From: Sarah Hufford [REDACTED]
Sent: 18 September 2018 16:45
To: Simon Davis
Cc: Conservation Officer; Planning.Responses
Subject: RE: BR/204/18/PL & BR/203/18/L - Bath House, The Steyne, BR

From: Sarah Hufford
Sent: 18 September 2018 16:41
To: 'Simon Davis' <Simon.Davis@arun.gov.uk>
Cc: 'Conservation Officer' <Conservation.Officer@arun.gov.uk>; 'planning.responses@arun.gov.uk' <planning.responses@arun.gov.uk>
Subject: RE: BR/204/18/PL & BR/203/18/L - Bath House, The Steyne, BR

In response I attach Plan 104B to replace 104A.

PROPOSED FLOOR PLAN , FLAT 6

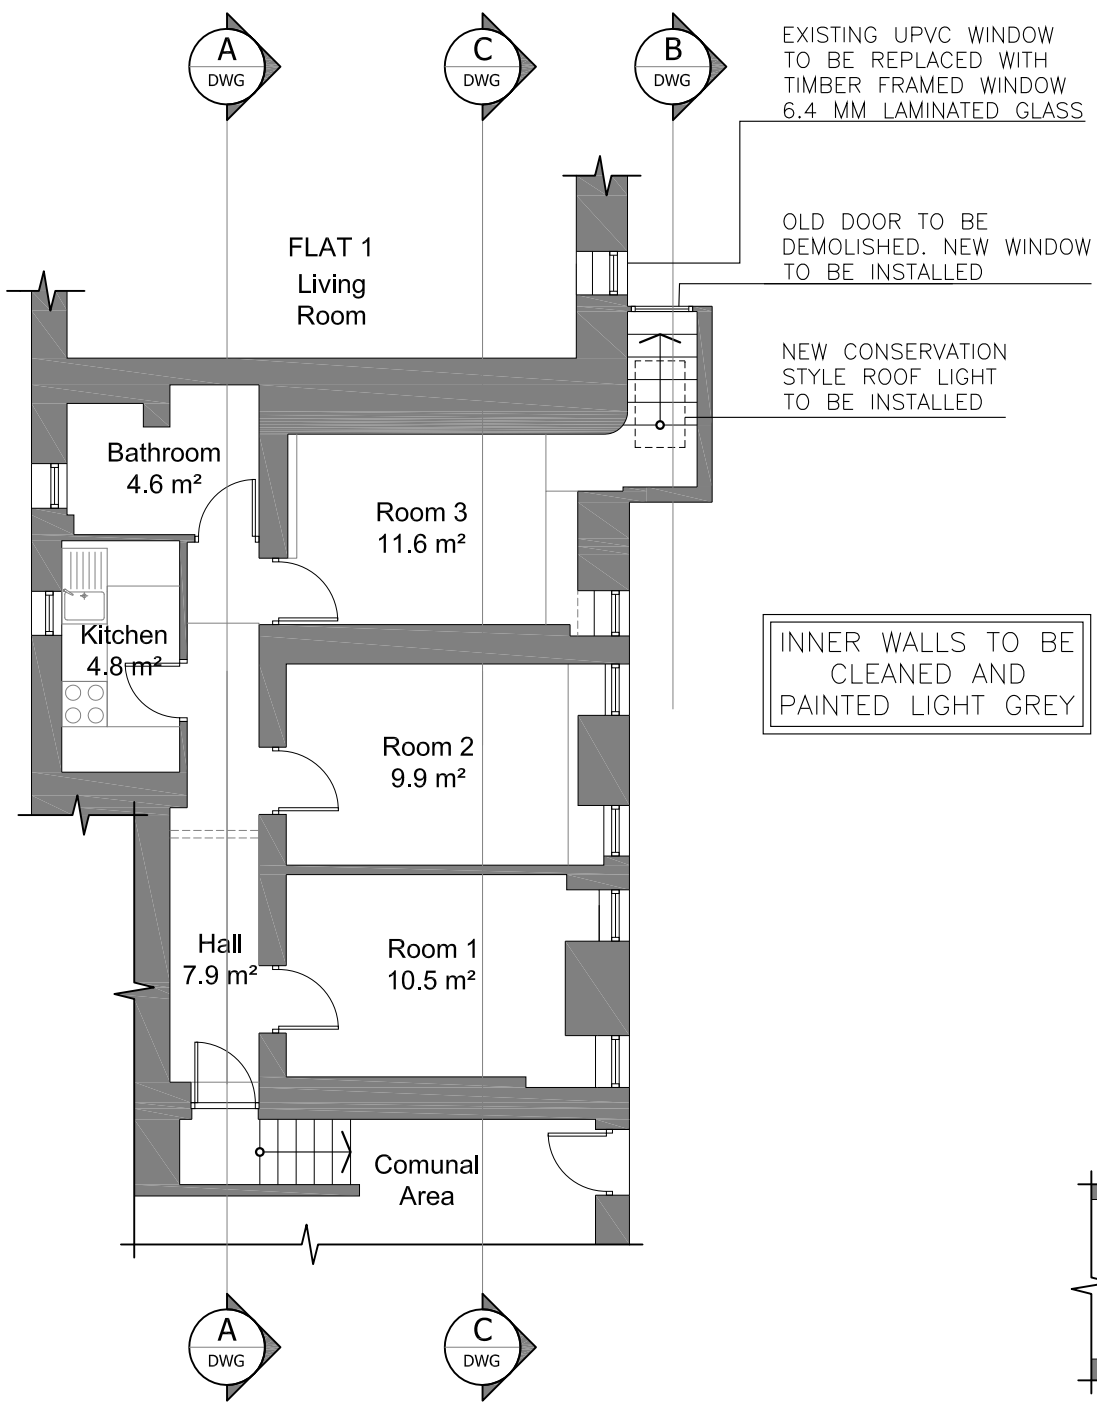
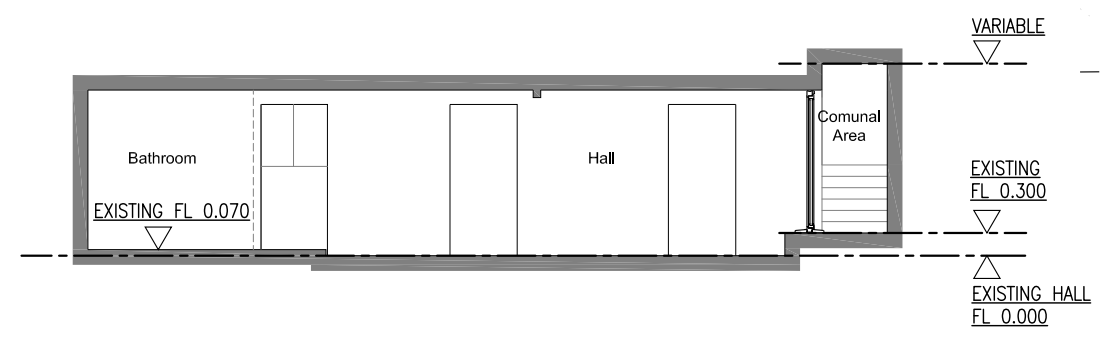
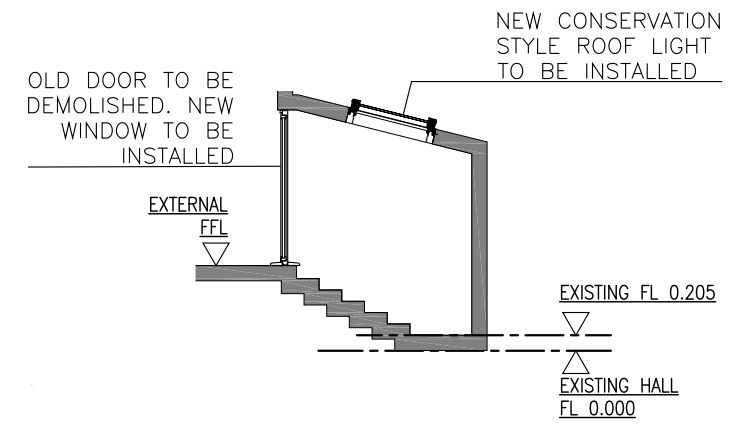
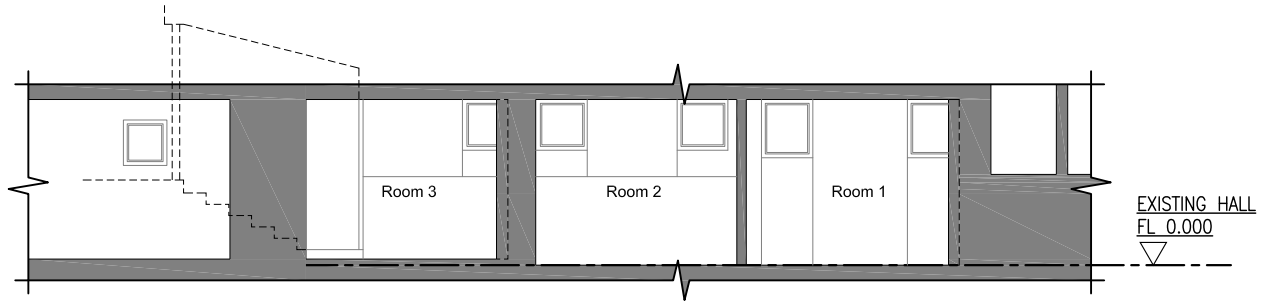
The side passage is visible from the Steyne and the proposed replacement window and masonry is considered will have a positive impact. However, it is not clear what the proposed windows will look like and details will need to be provided by way of condition. It is considered that the proposed windows will not be visible from the conservation area, and not cause any harm.

Sorry Panel below not panel window.

This clarifies the proposed window [in place of the door] as a new three quarter height timber vertical sash window with panel window.
